### Hearing Action Points

Application by Norfolk Boreas Limited for an Order Granting Development Consent for the Norfolk Boreas Offshore Wind Farm Project.

Actions arising from the Offshore Effects including the draft Development Consent Order hearing held at Blackfriars Hall, St Andrew's Plain, Norwich, NR3 1AU on Wednesday 22 January 2020.

Relationship of Offshore Plans secured by the DCO (Generation DMLs)

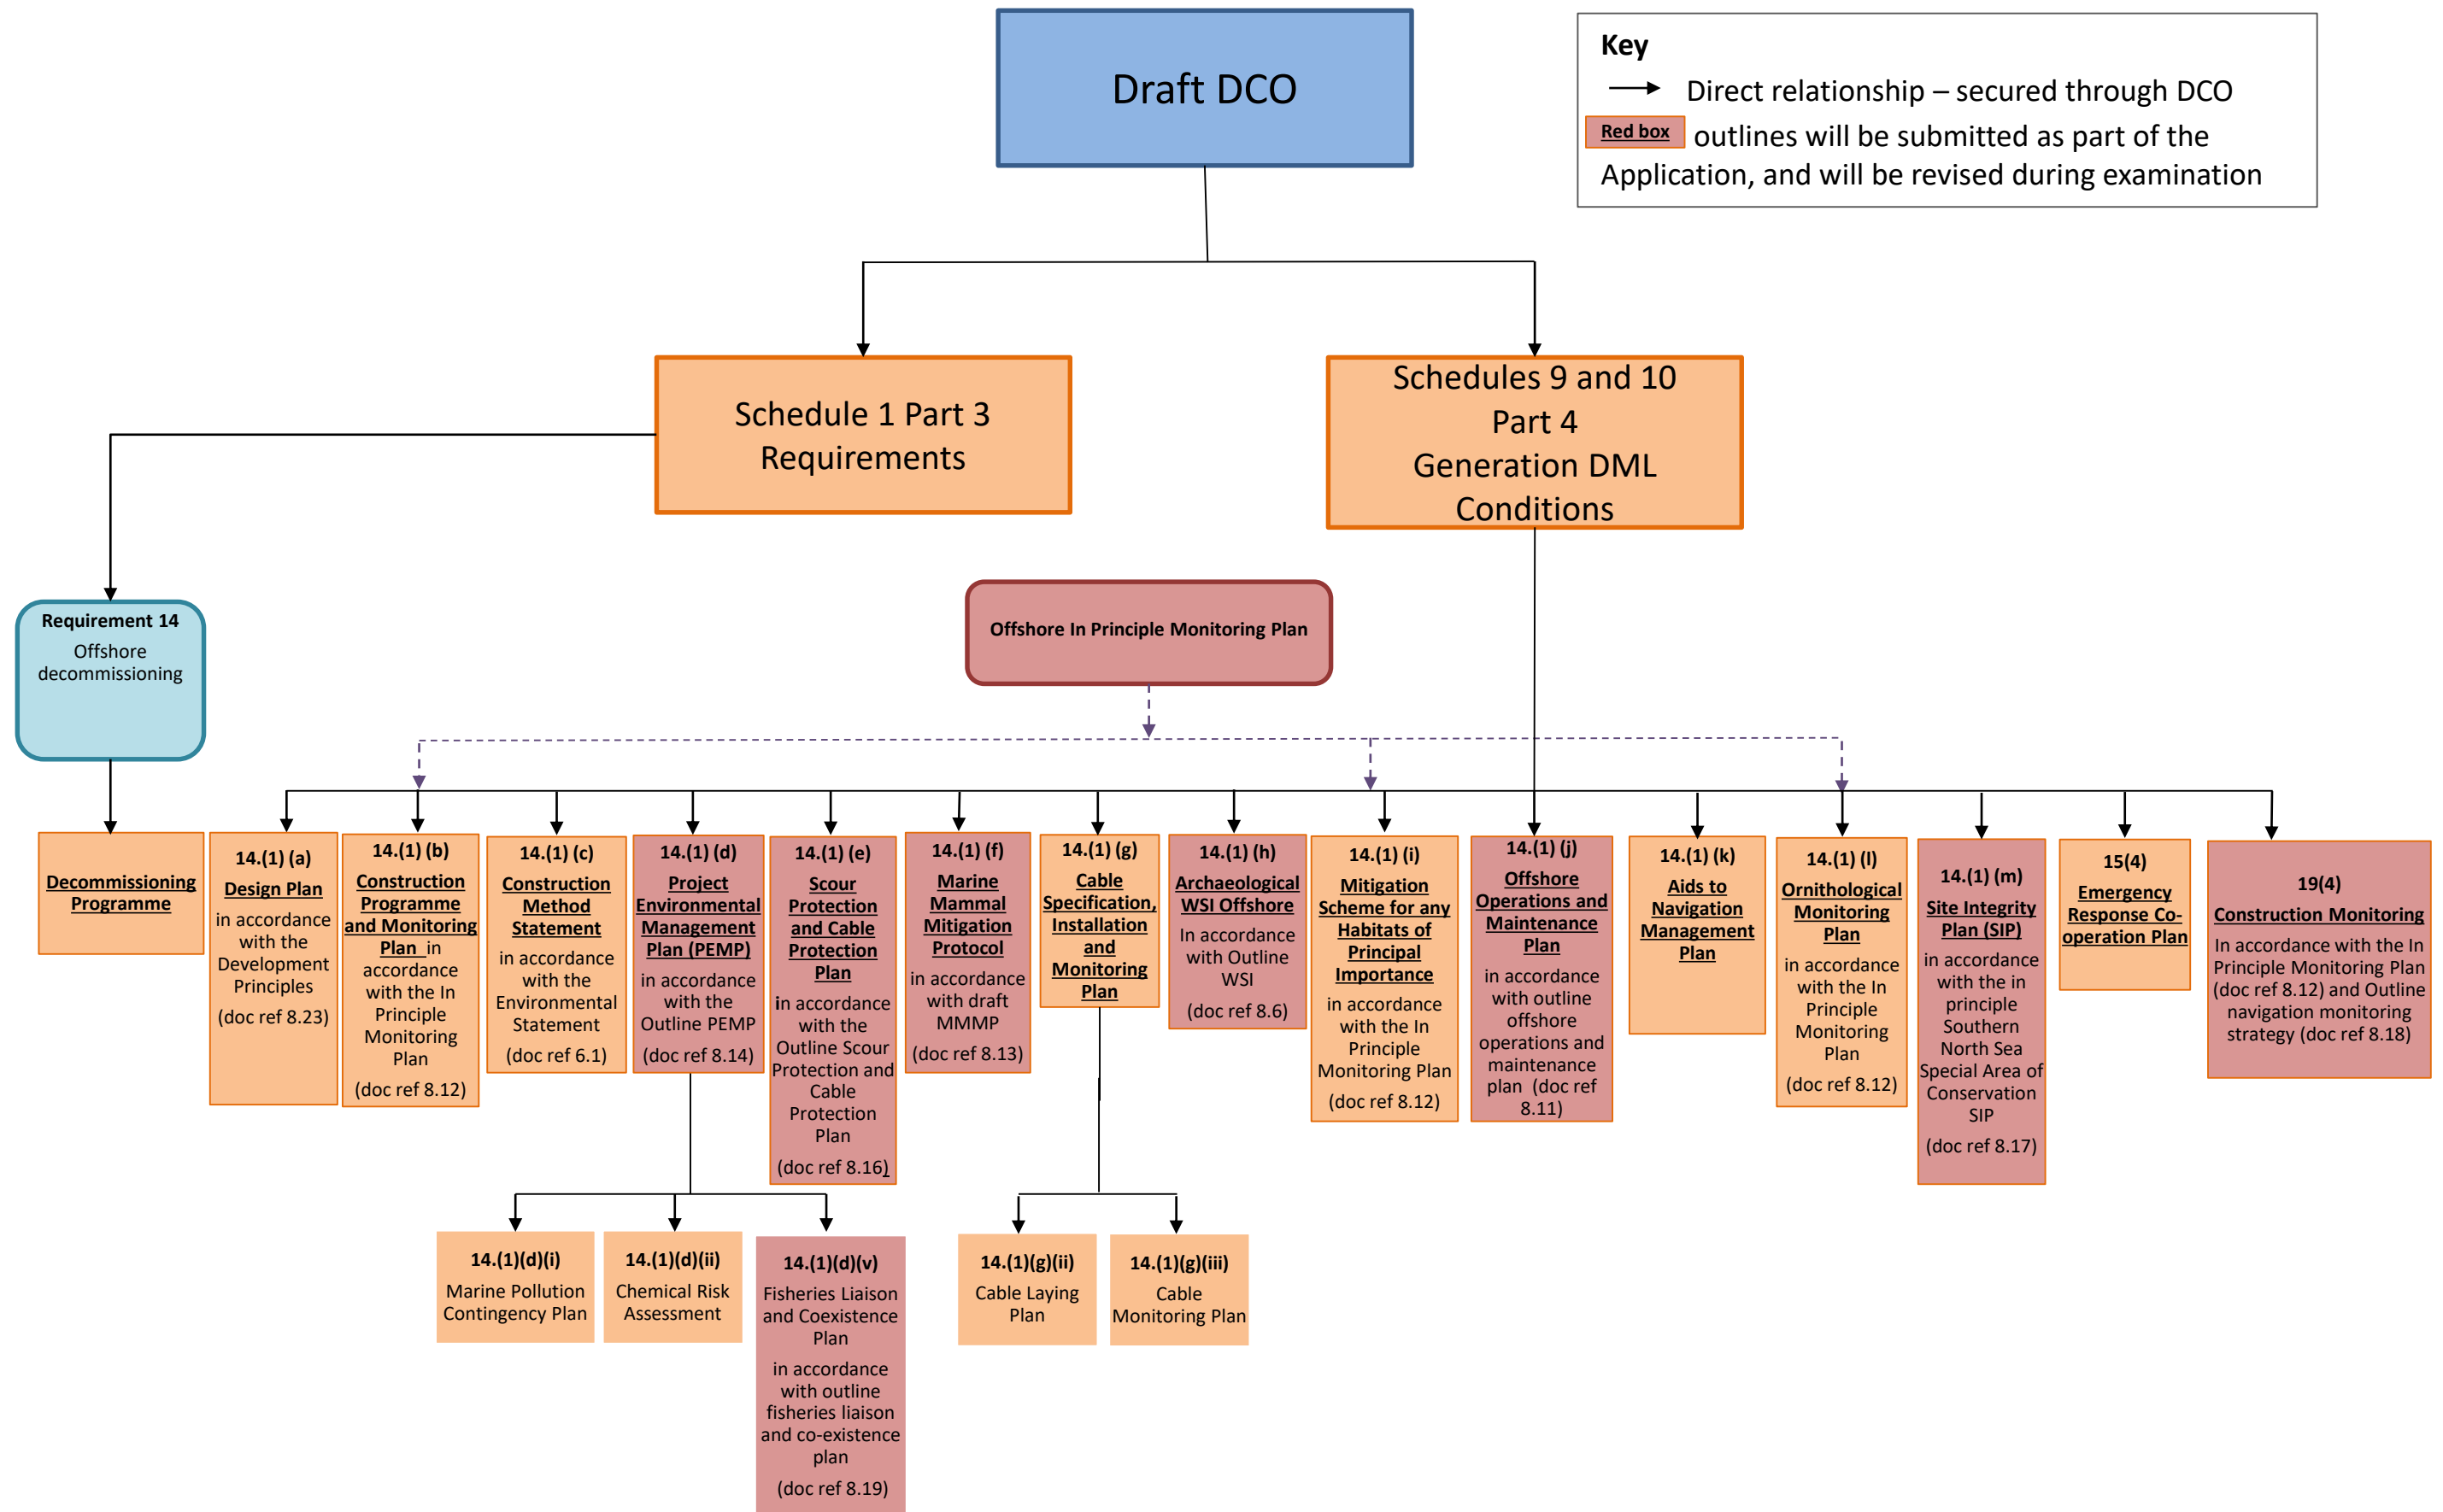
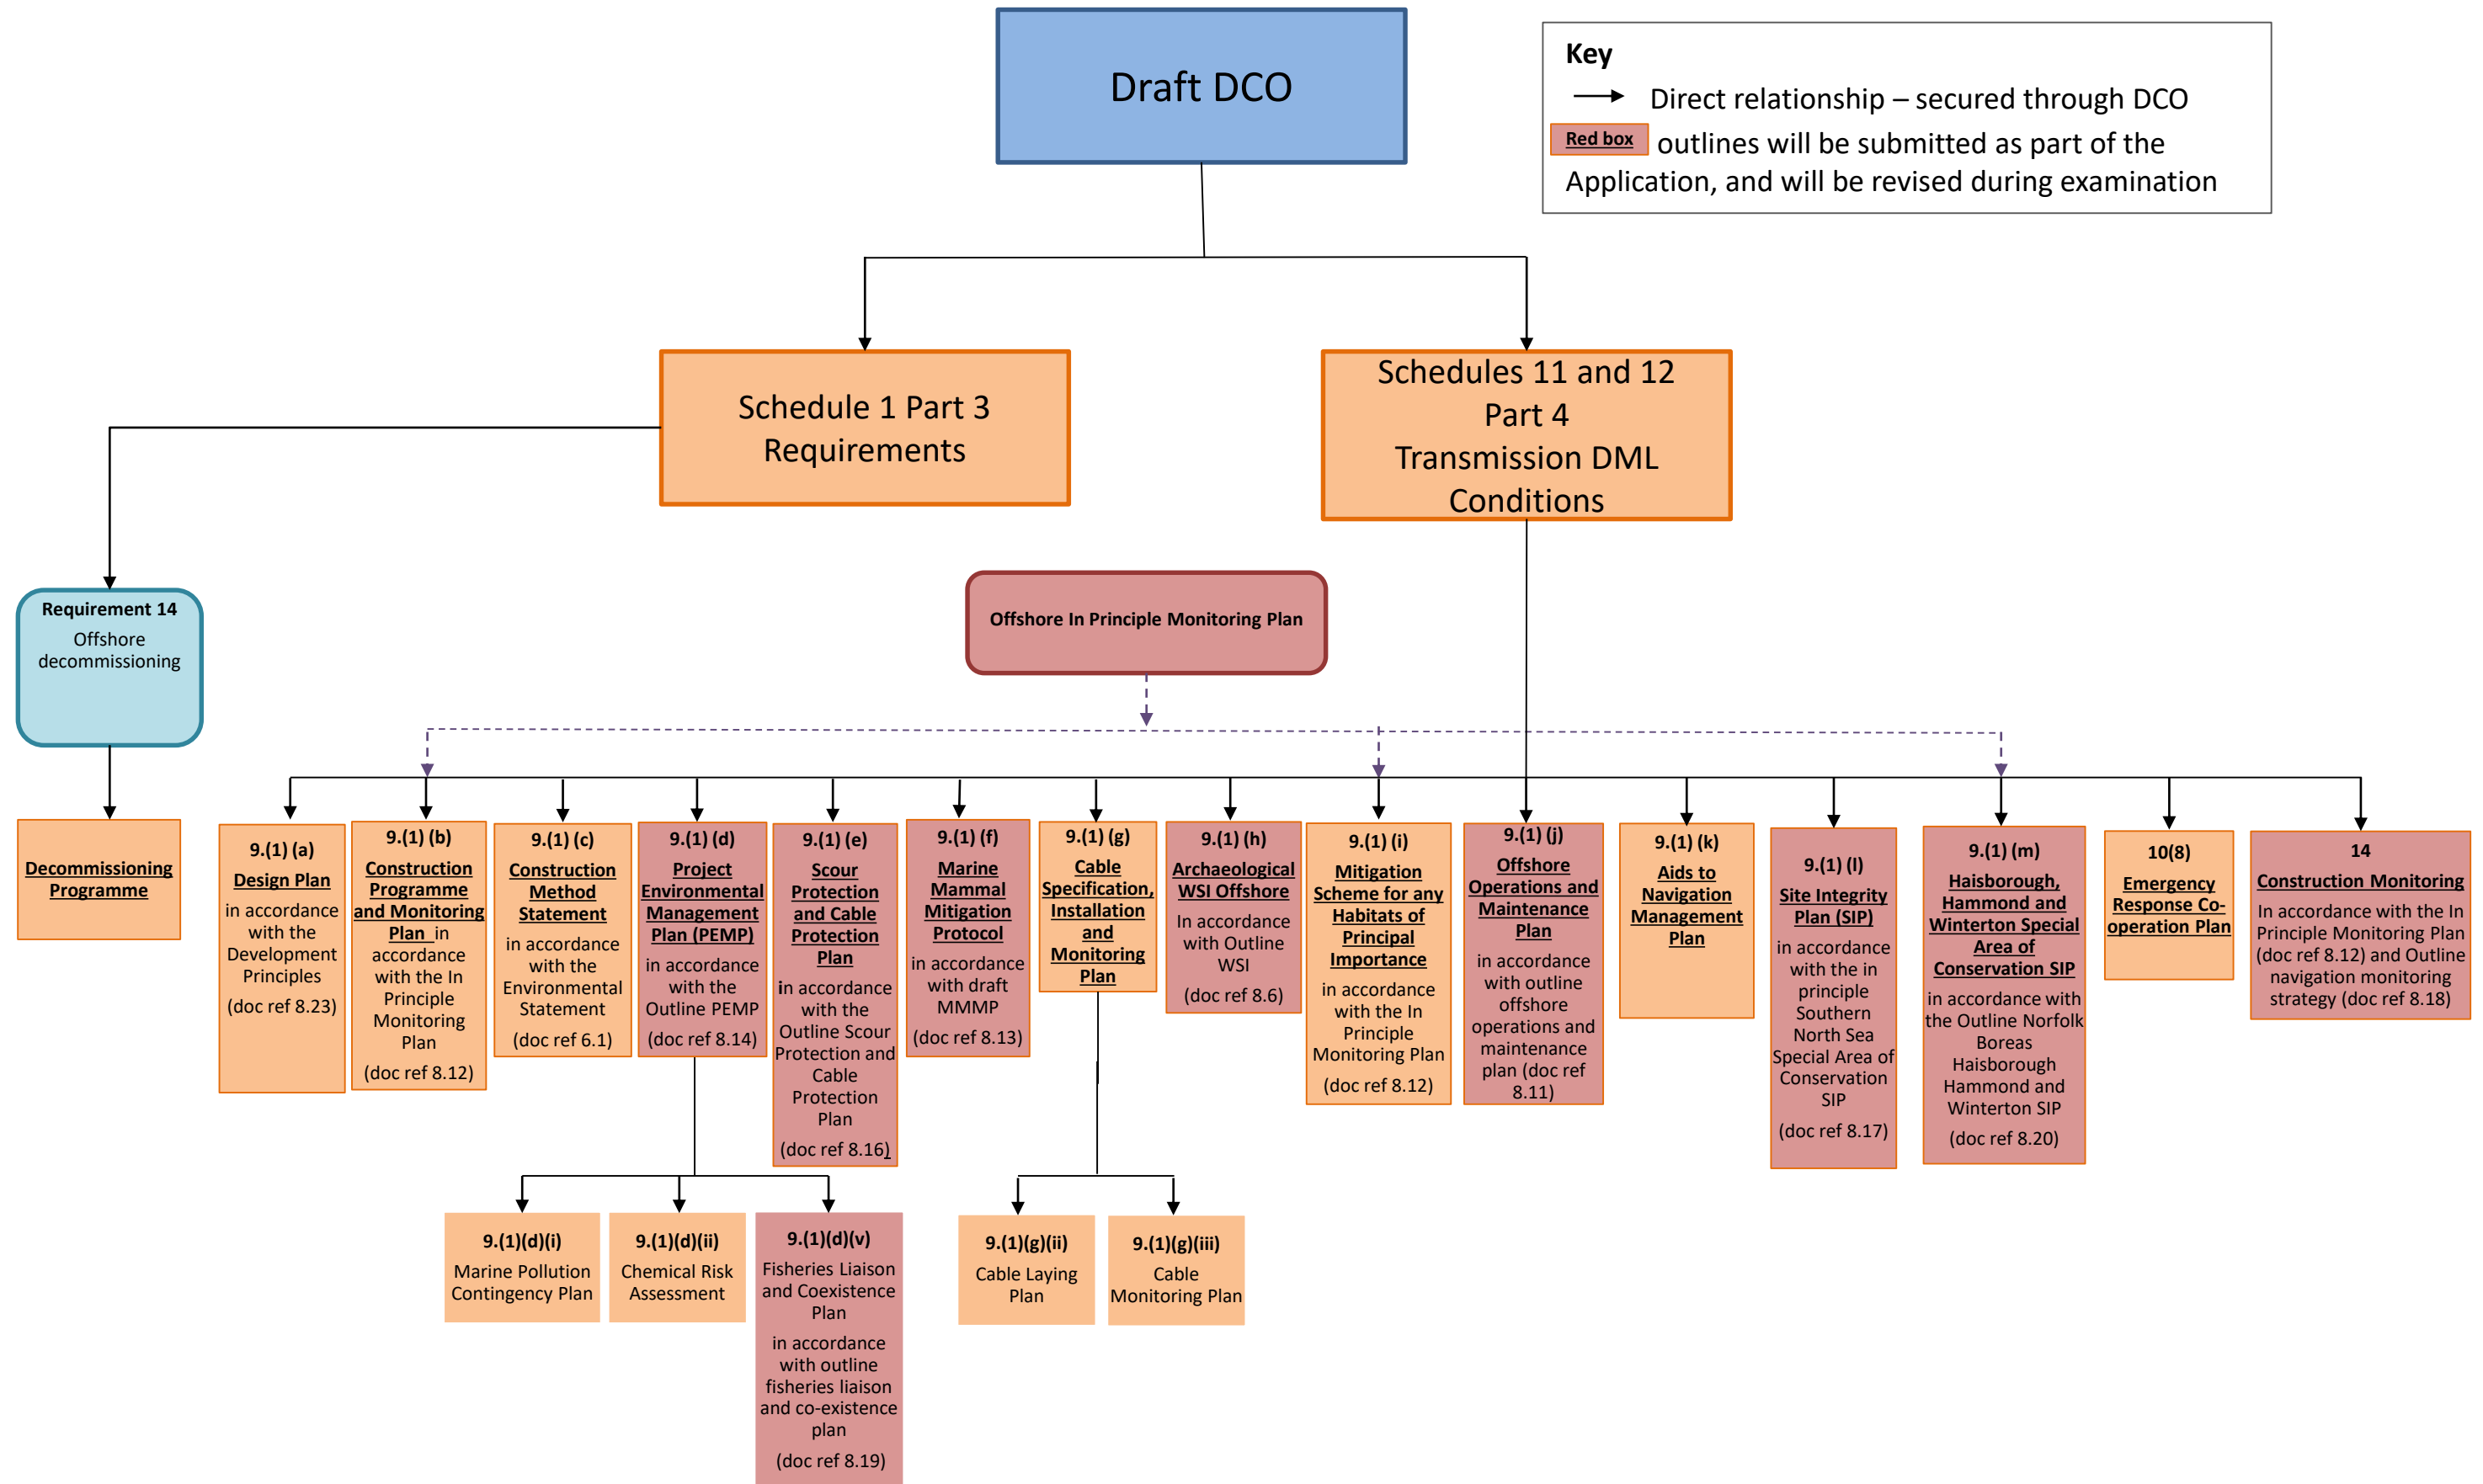
2.	Submit note to clarify how the offshore In Principle Monitoring Plan relates to the DCO and to the DML Conditions and to the various plans secured under the DML conditions (currently shown as a partial pecked line relationship in the [APP-022] diagrams) and what cross-referencing is necessary.	Applicant	D4
